**EL PASO COUNTY PLANNING AND
 COMMUNITY DEVELOPMENT
 DEPARTMENT**

GRADING AND EROSION CONTROL PLAN CHECKLIST

Creekside South at Lorson Ranch

CREEKSIDE SOUTH AT LORSON RANCH  
OVERLOT EARLY GRADING AND  
EROSION CONTROL PLAN

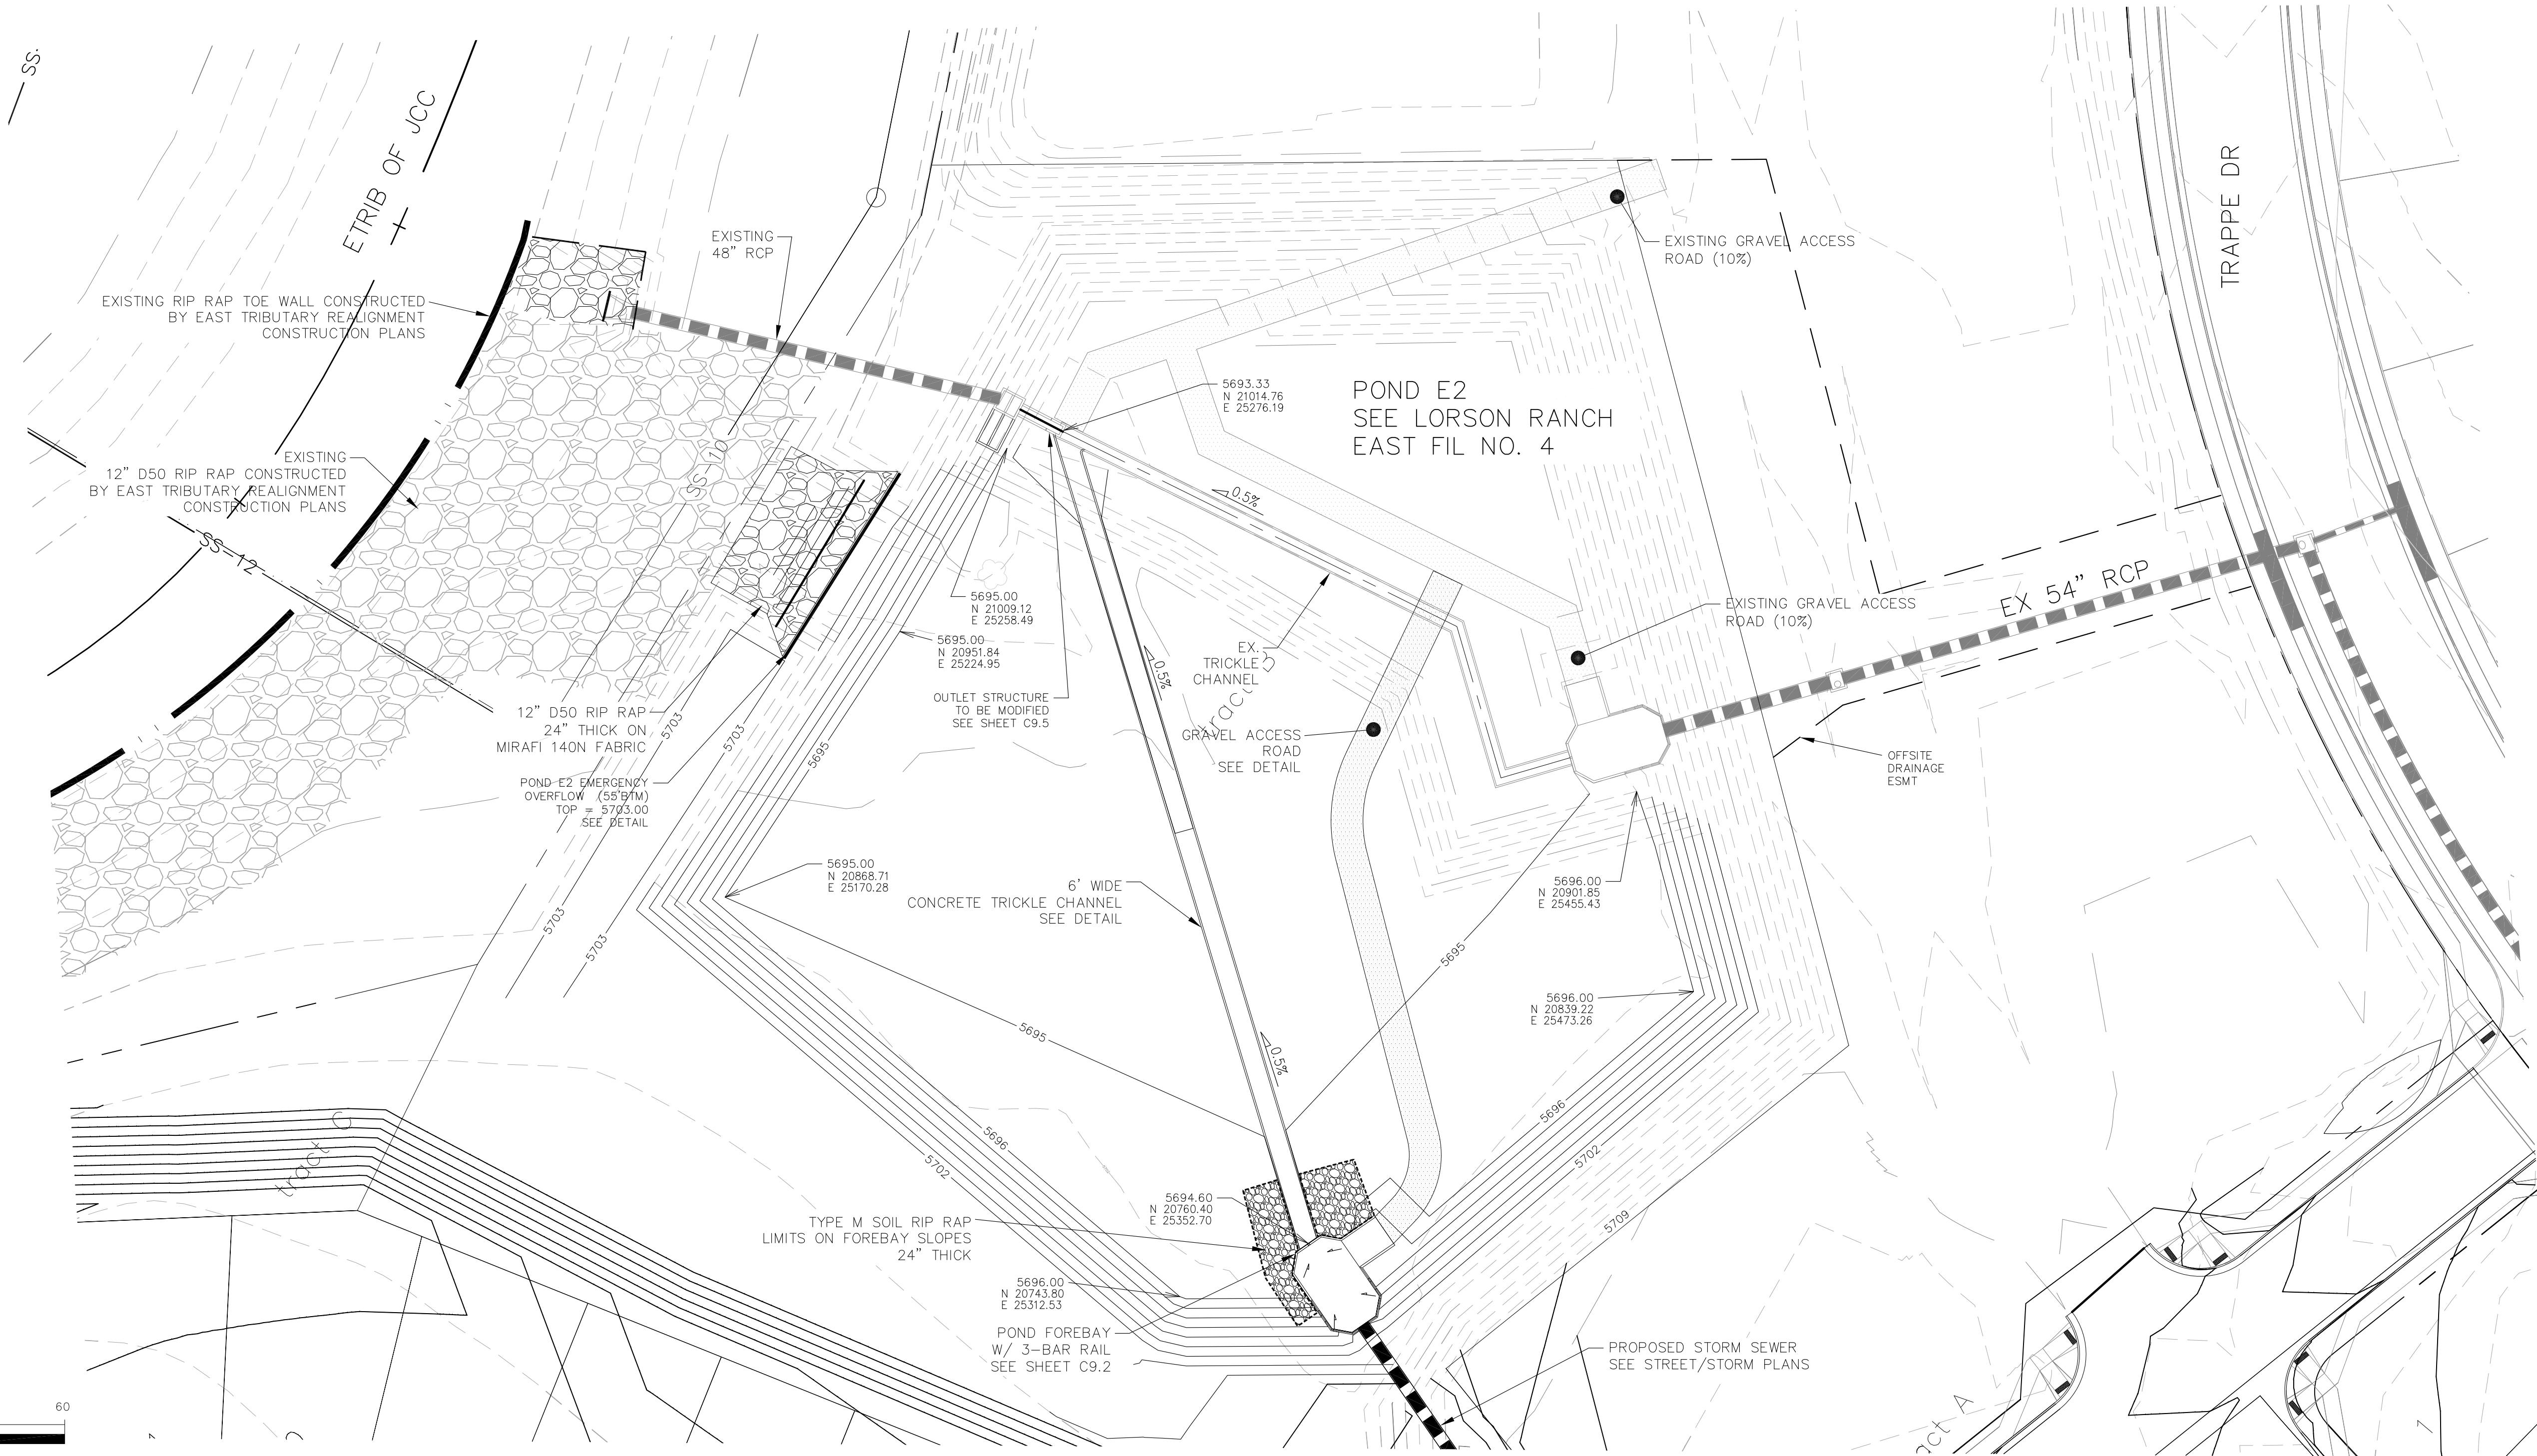
| | | Applicant | PCD |
|--|---|-----------|-----|
| d | Legend for all symbols used in the plan. | y | ✗ |
| f | All existing structures. | y | ✗ |
